# TILBURY2

EXPLANATION OF CHANGES TO DRAFT  
DEVELOPMENT CONSENT ORDER

### EXPLANATION OF AMENDMENTS MADE TO THE DRAFT DCO AT DEADLINE 1 (REV 1)

REVISED LIMITS OF DREDGING PLAN
TILBURY 2 DOCUMENT REF: POTLL/T2/EX/45

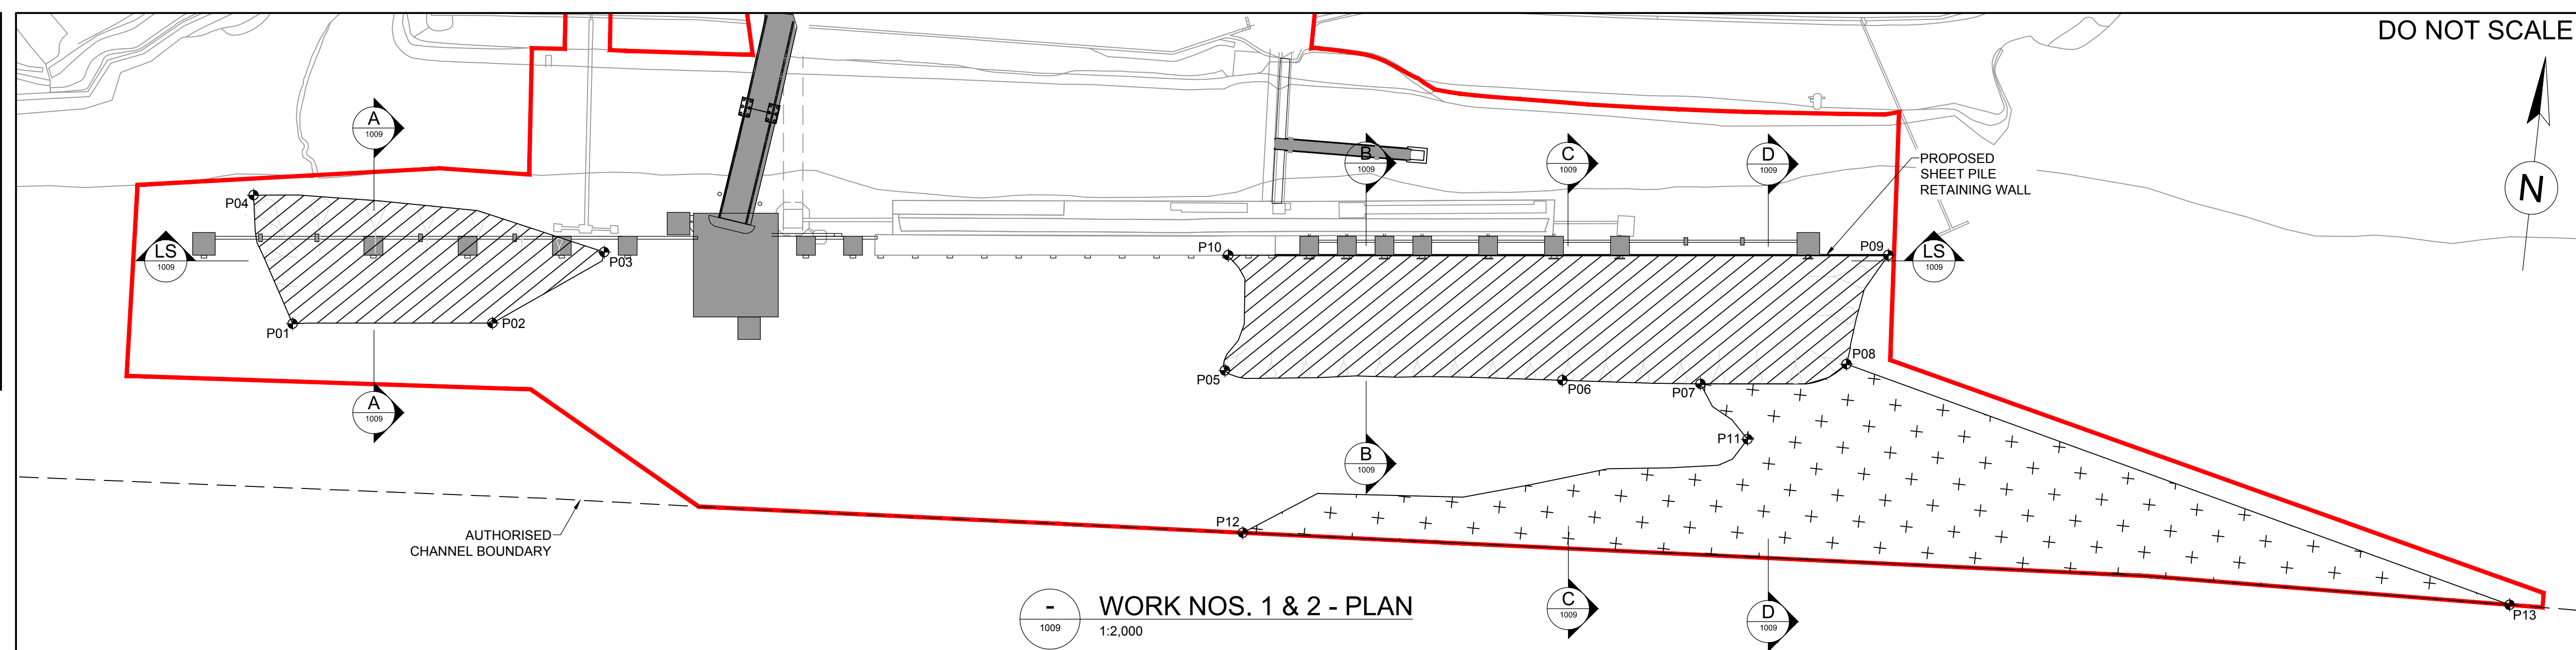
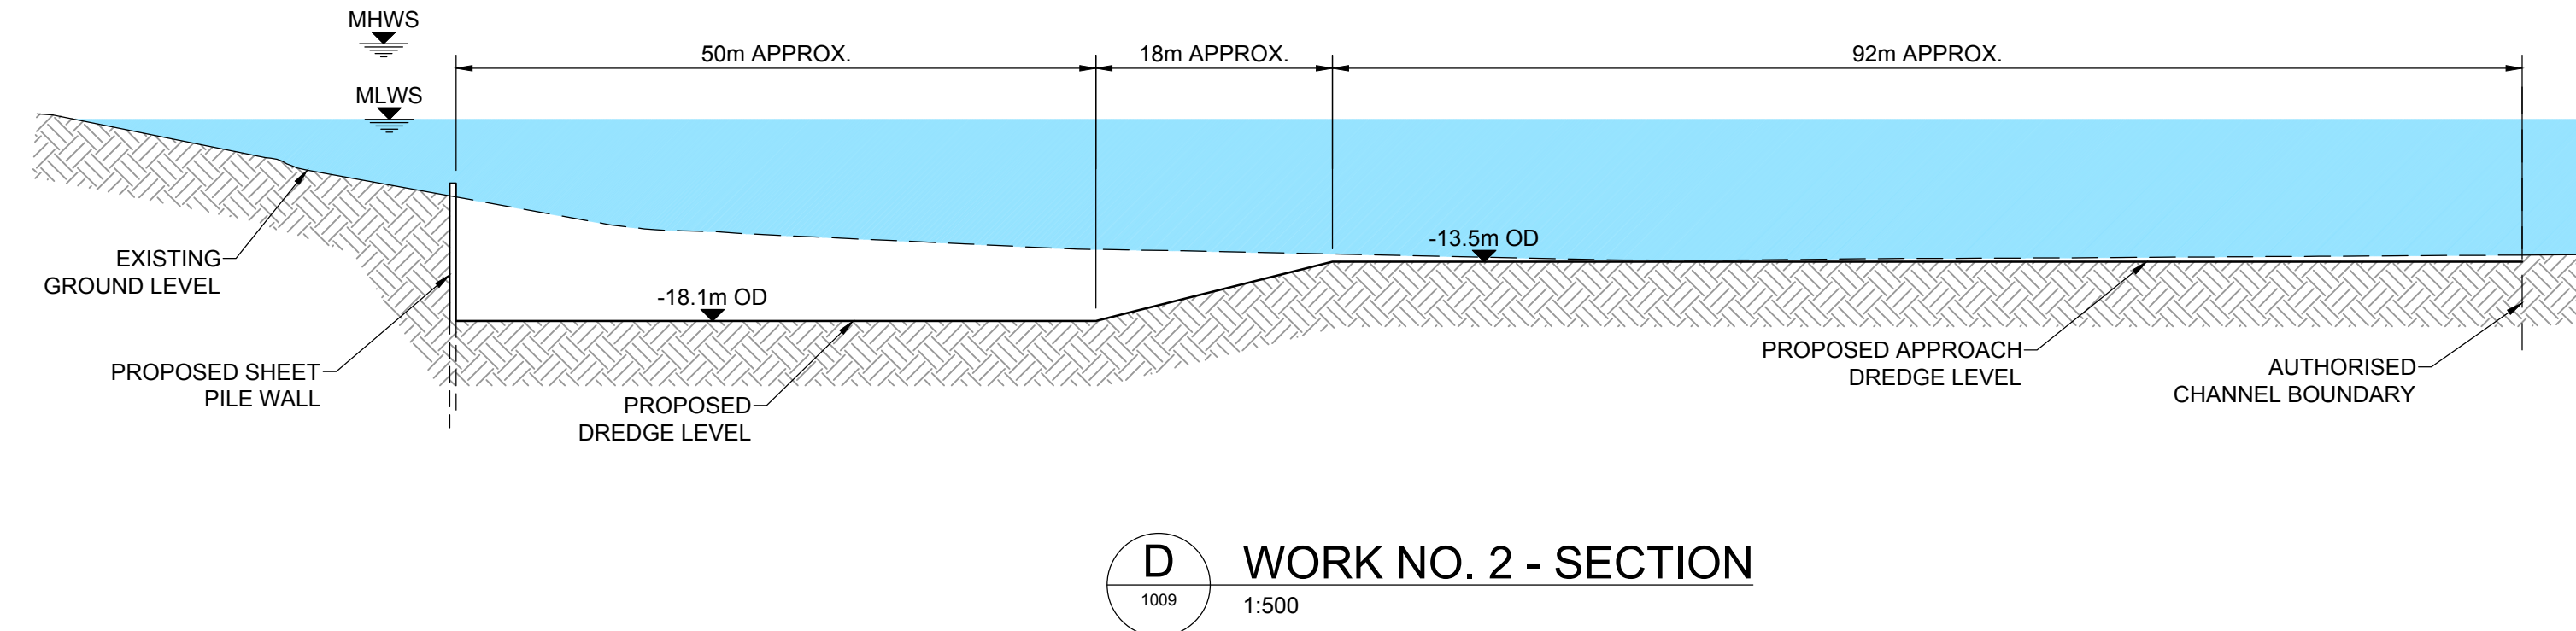
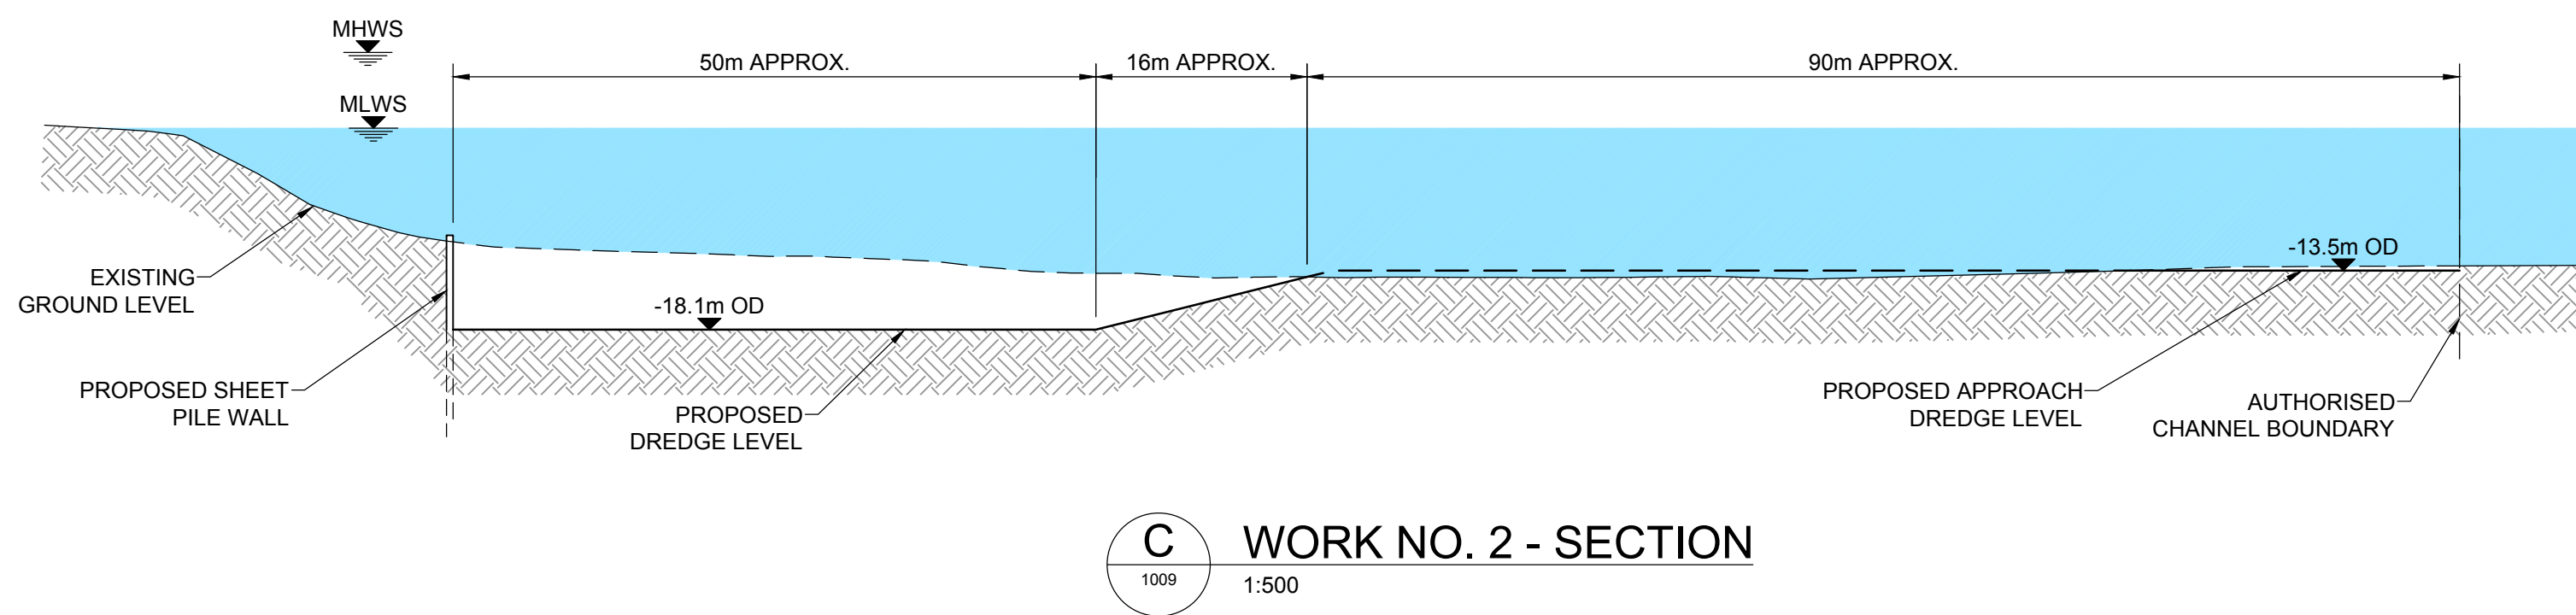
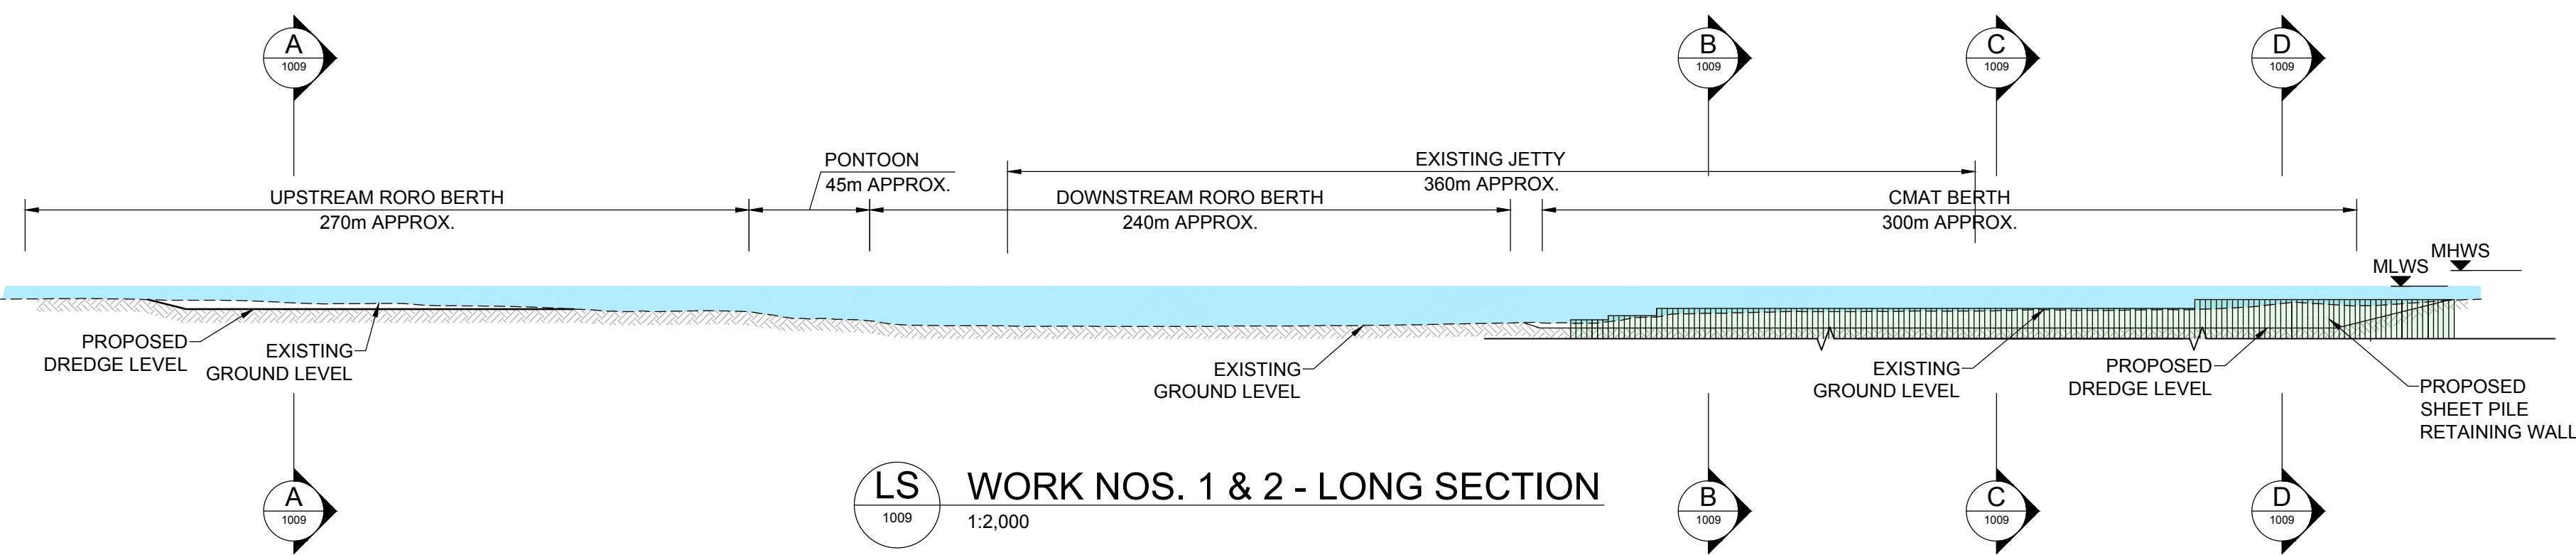
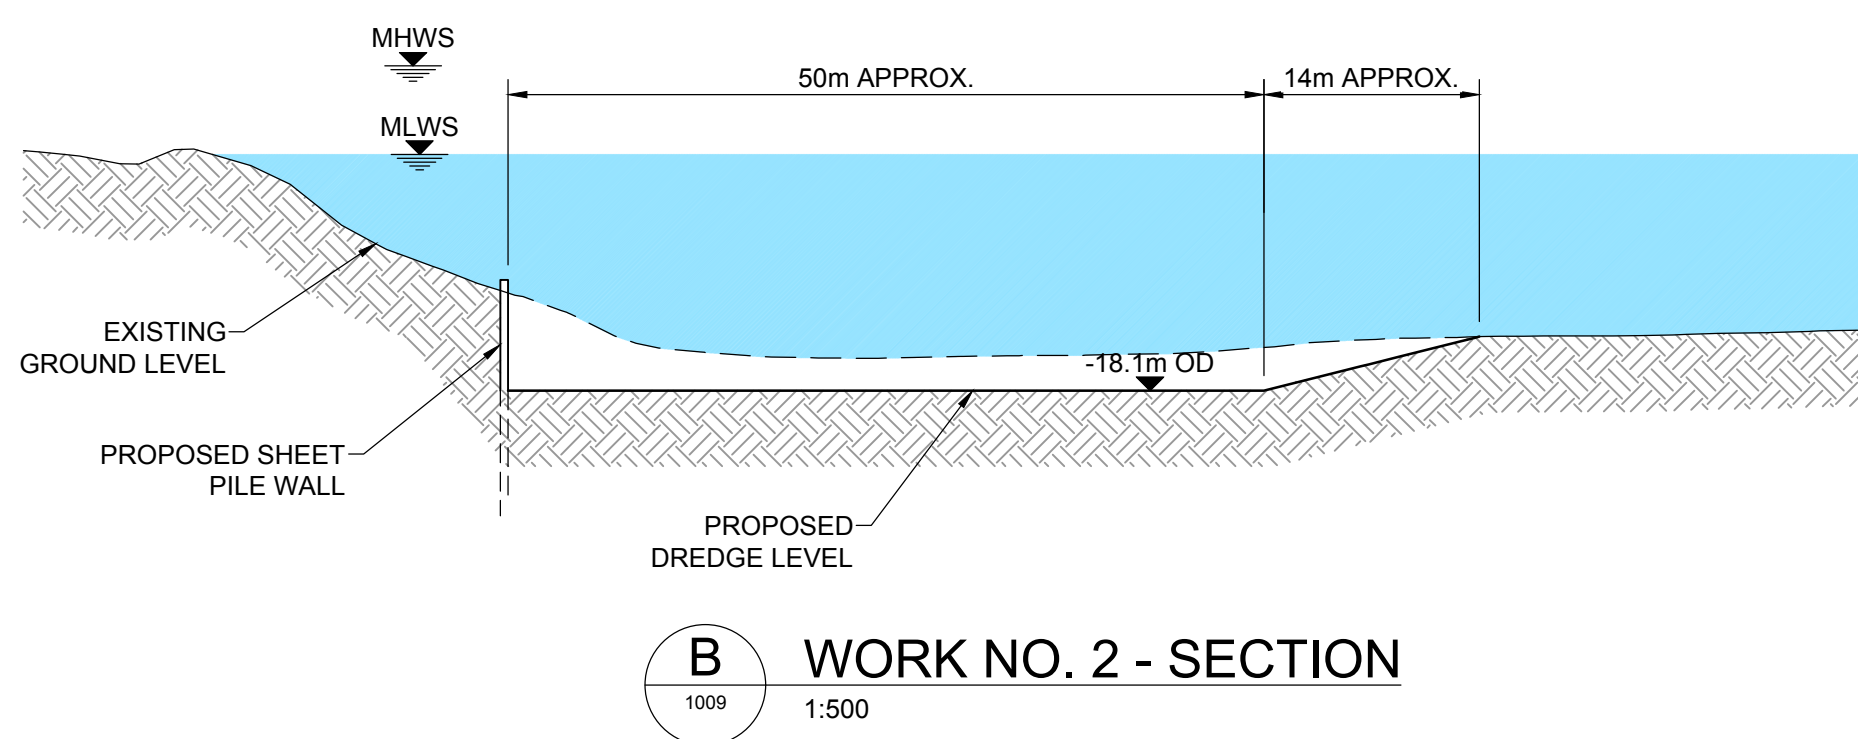
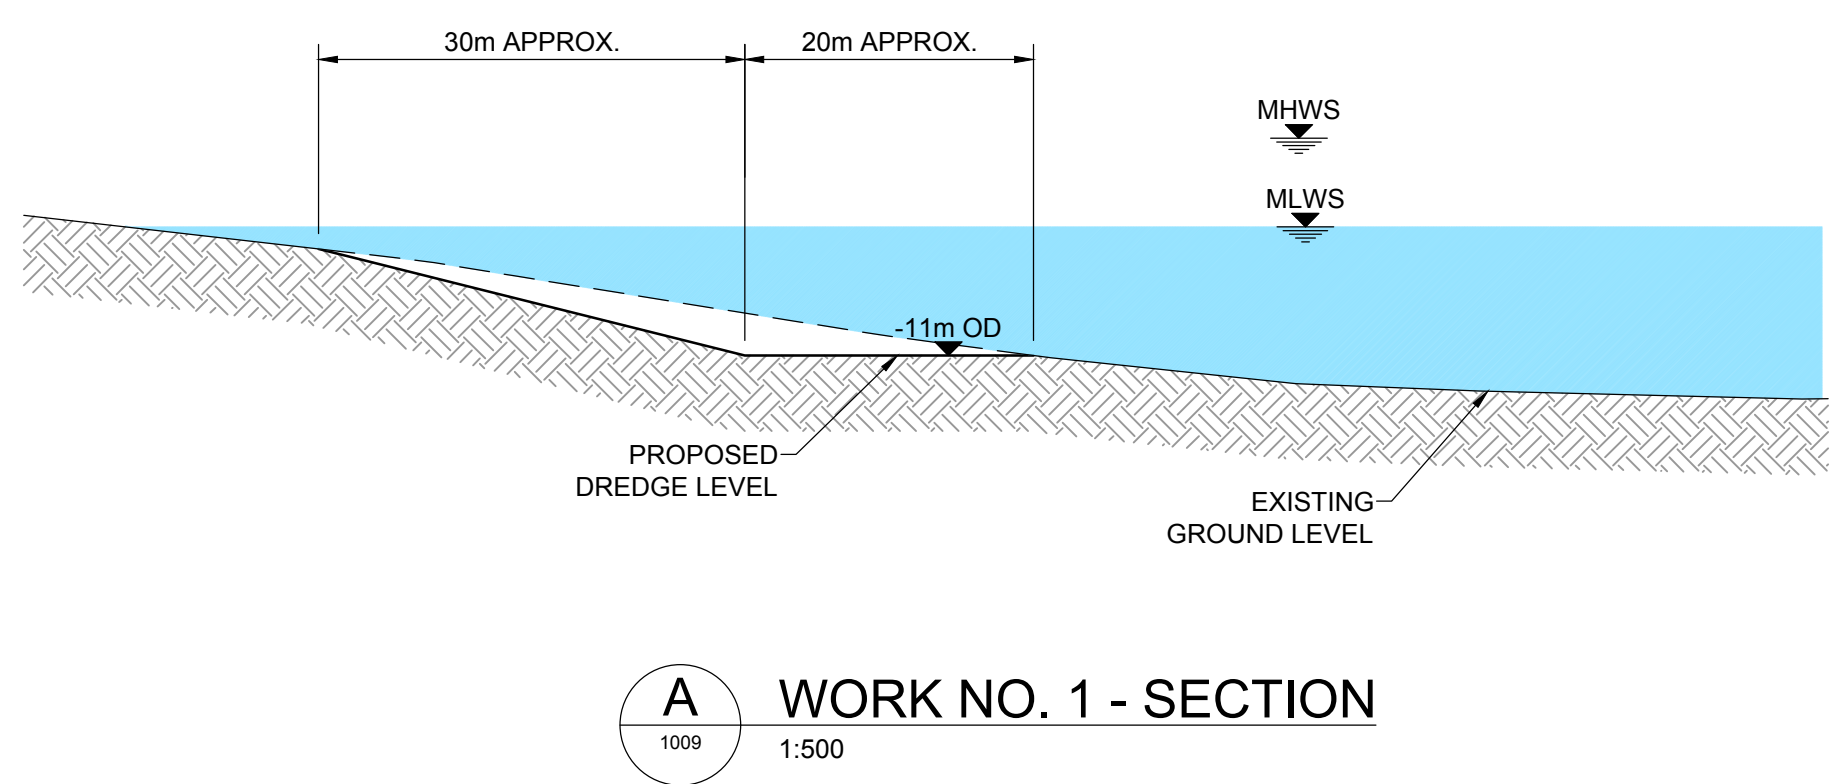
Provision in revised draft DCO and/or issue	Brief description and explanation
	limits does not apply to functions covered by section 64 (use of Thames Water) of the 1968 Act in respect of the discharge of water to the river Thames.
Article 5	<p>This article has been amended in response to ExA's comments at point 14 of the ISH agenda:</p> <ul style="list-style-type: none"> <li>(a) summary headings in relation to each section to be incorporated have been amended to the heading for that section as set out in the Railway Clauses Consolidation Act 1845;</li> <li>(b) the definition of "prescribed" has been removed as matters in the DCO are not prescribed by the Order for the purpose of that provision; and</li> <li>(c) the definition of "the railway" has been amended and narrowed as the scope of "any other authorised works" is arguably broader than is strictly necessary.</li> </ul>
Article 7	This article has been amended to incorporate the limits of dredging plan showing the maximum dredging depths as per the amendment to article 2(1) above.
